**Hinkley Point C (Nuclear Generation Company) Statutory Order 2013 made 18th March 2013:
Application for a Non-Material Change in relation to the Hinkley Point C Main Development Site
Response to interested party representations**

ANNEX – Response to Interested Party Representations

Site layout Plan (Operational)
Regulation 5(2)(o)

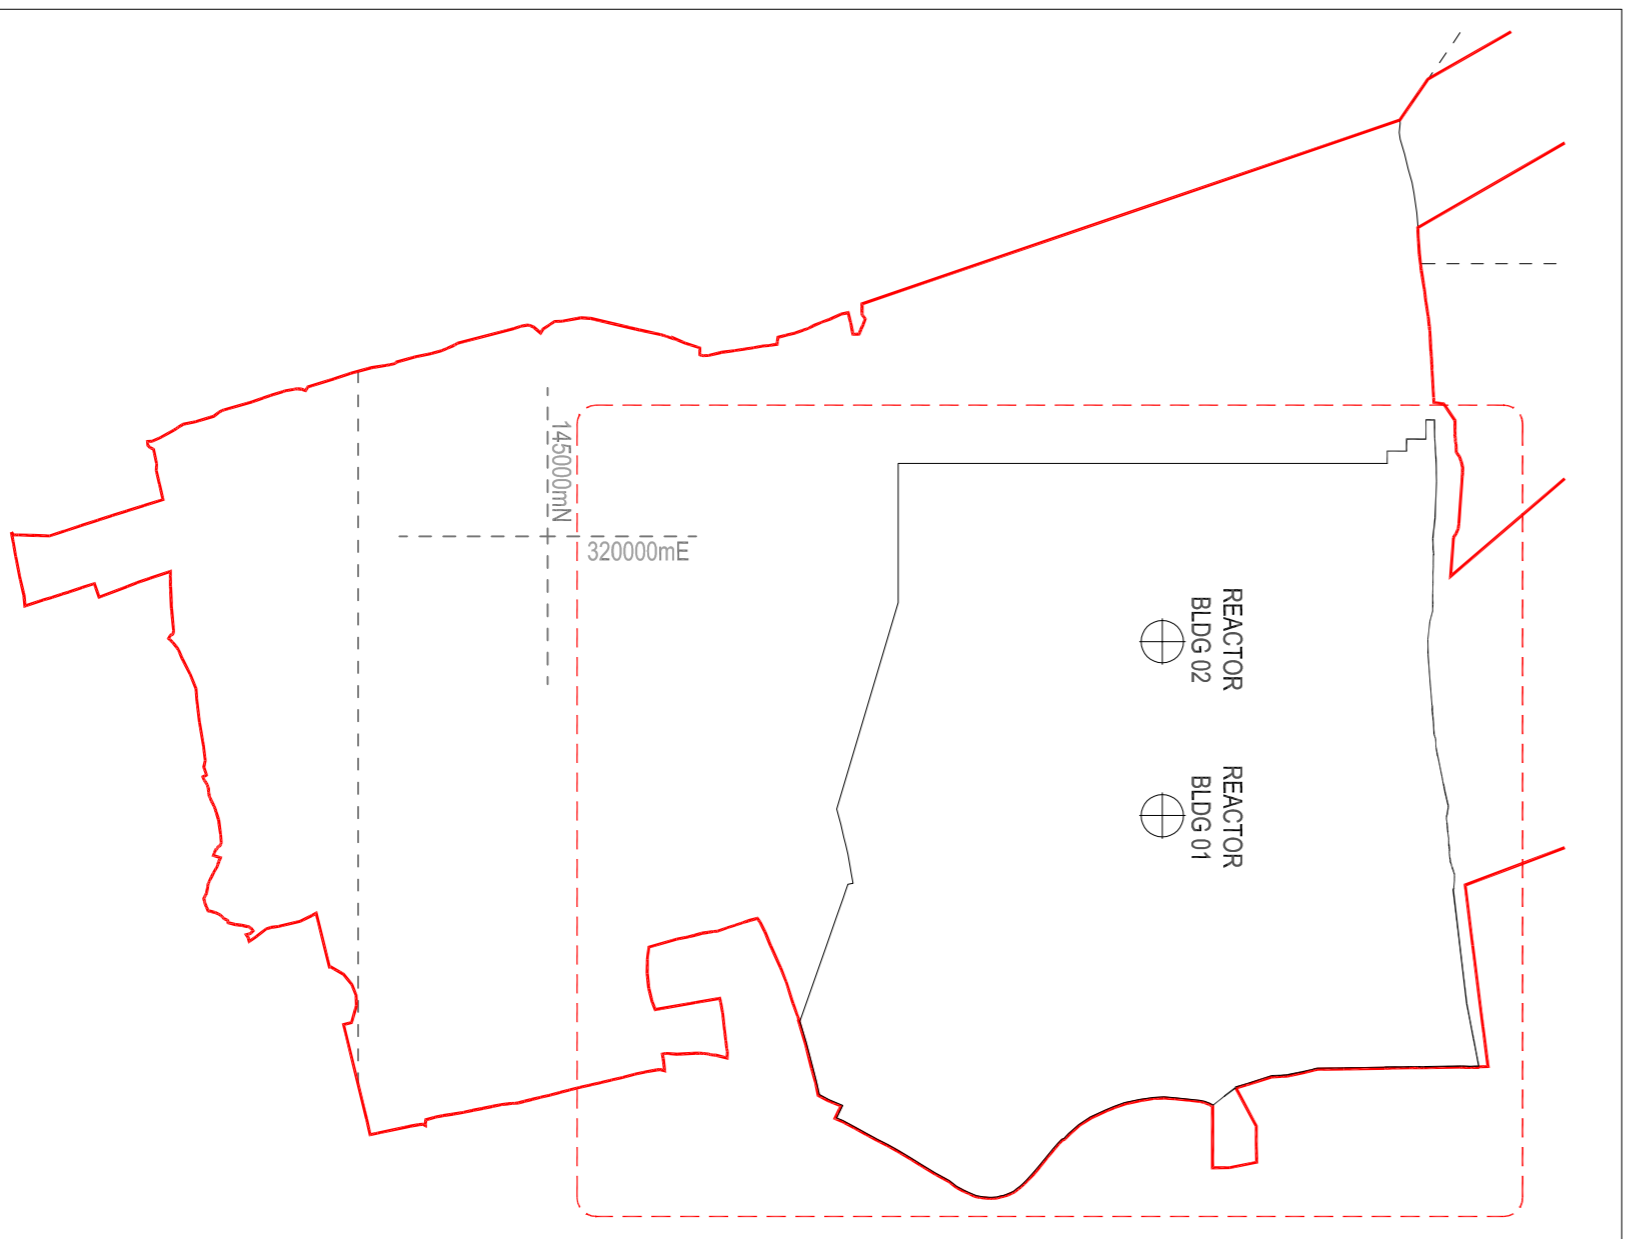
2.6	The Emergency Response Store on Site Layout Plan	<p>The Emergency Response Store has been removed as described in 2.4.8 to 2.4.9, and its functions moved into the proposed Back-up Emergency Equipment Store as described in 2.4.11 to 2.4.13 of the Application Statement. The proposed Back-up Emergency Equipment Store is located elsewhere on the Site (building 59 on the Site Layout Plan). The Oil & Grease Storage & Oil Ancillary Building would be moved to the site of the Emergency Response Store.</p>

DRAWING TITLE
Hinkley Point C Development Site
Emergency Response Energy Centre (HDU)
Roof Plan and Elevations
Regulation 5(2)(o)

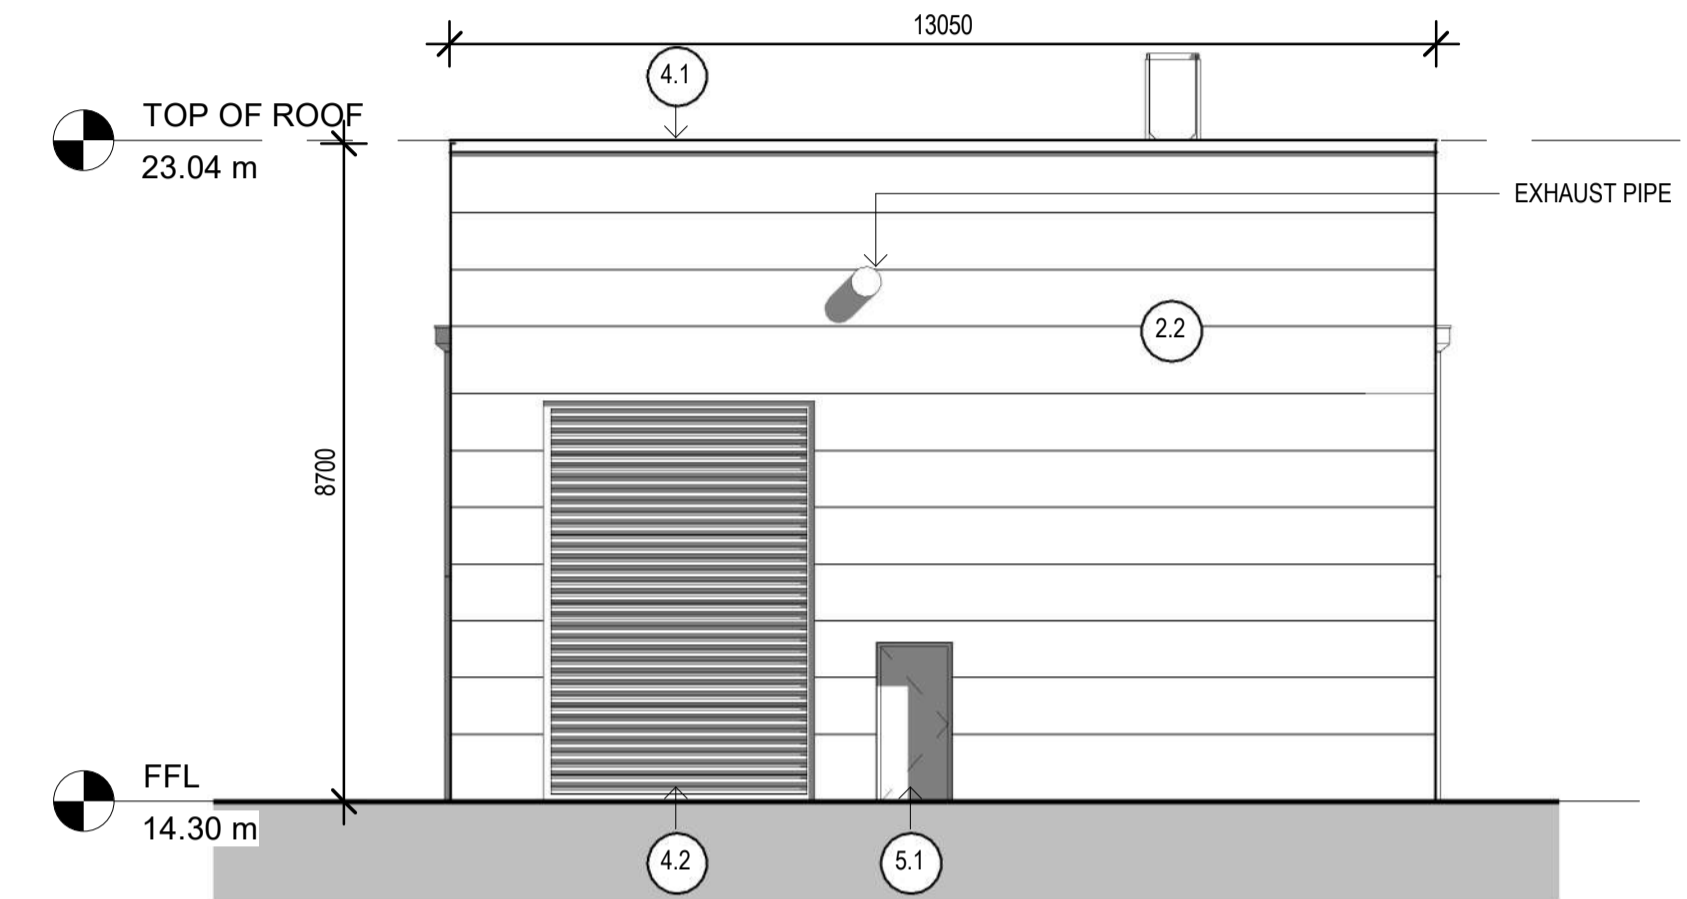
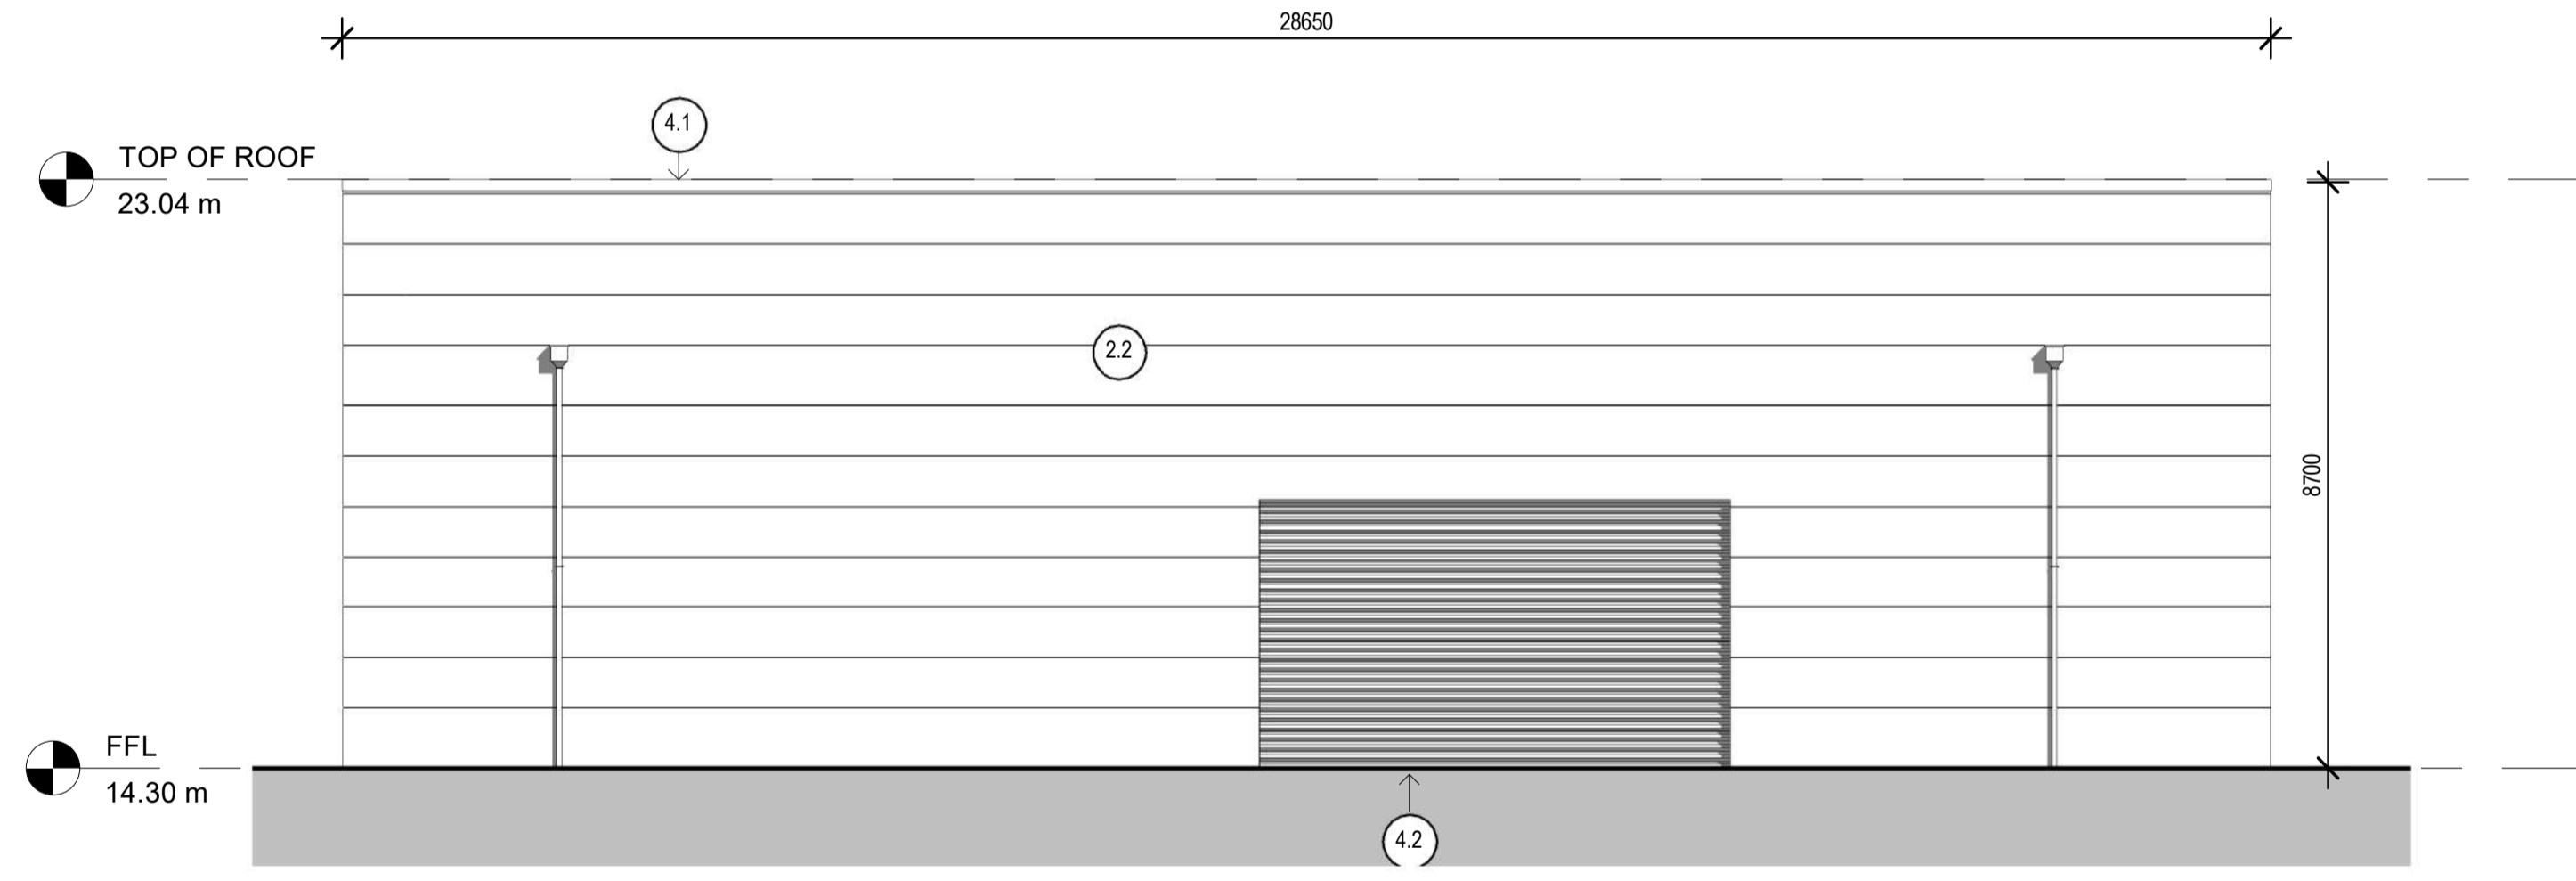
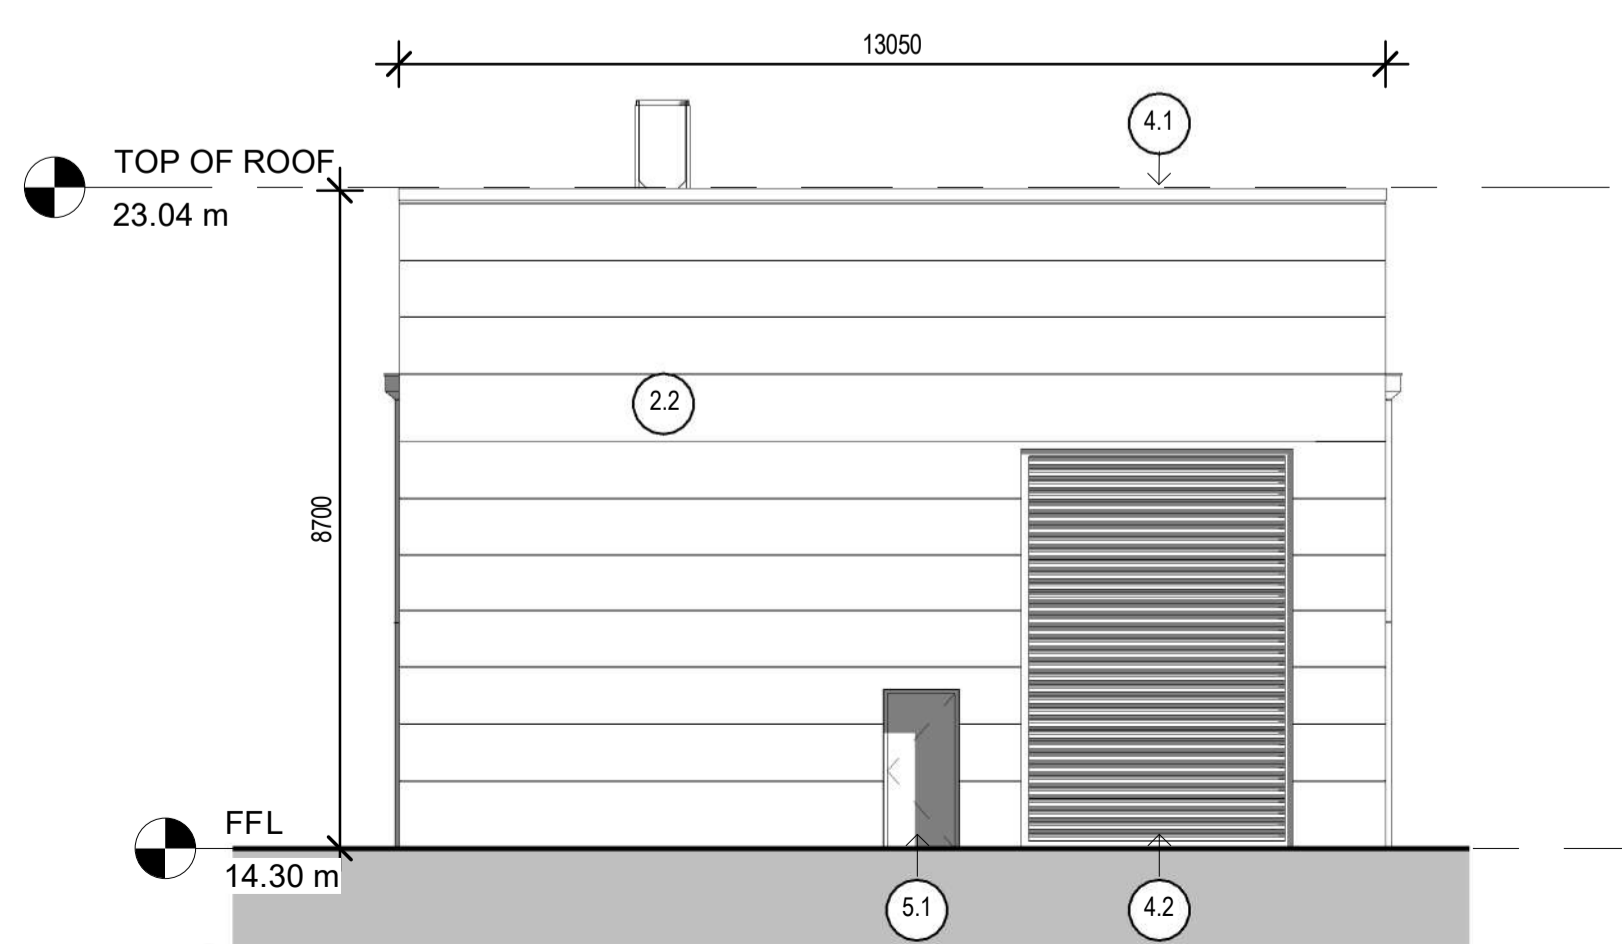
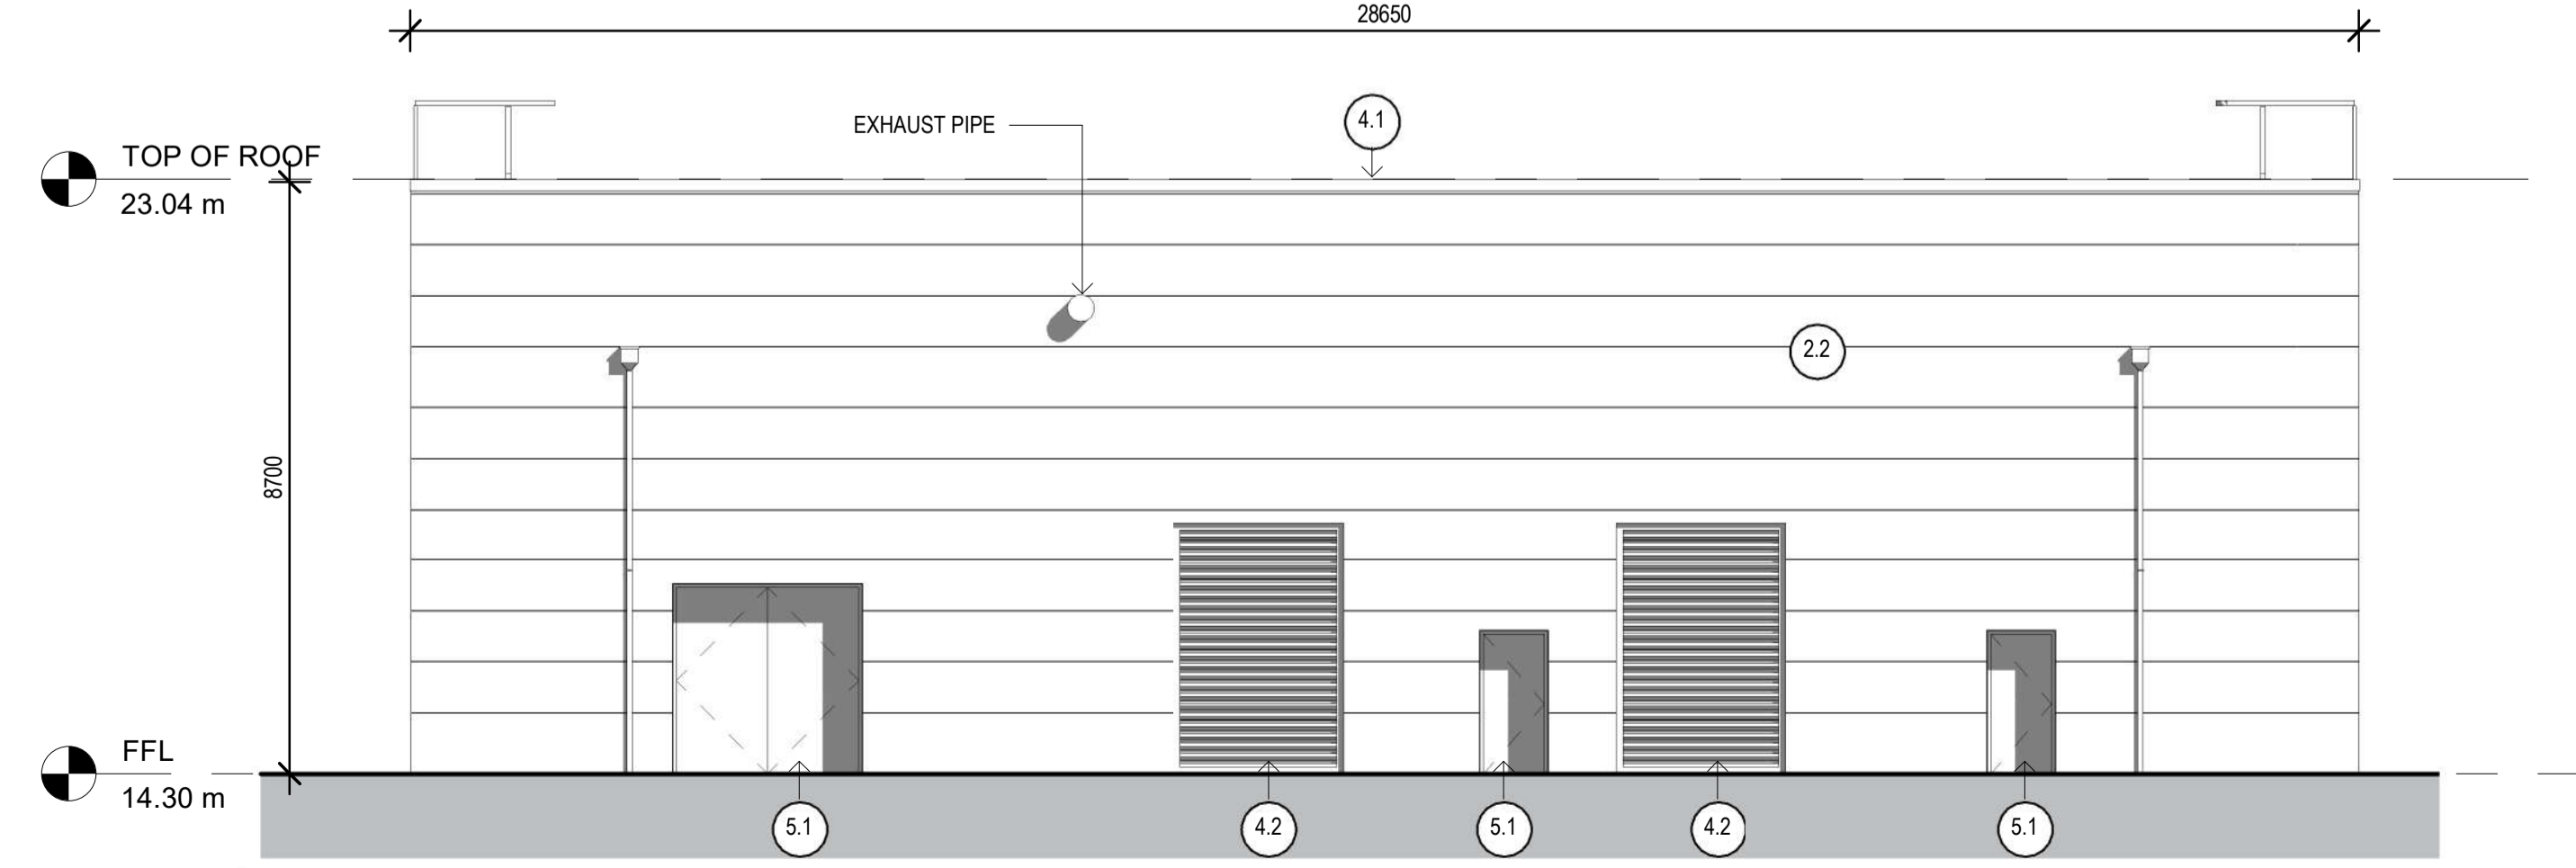
2.22	Emergency Response Energy Centre – Safety	The Emergency Response Energy Centre does avoid the Blue Anchor Formation. It is a seismically qualified building.
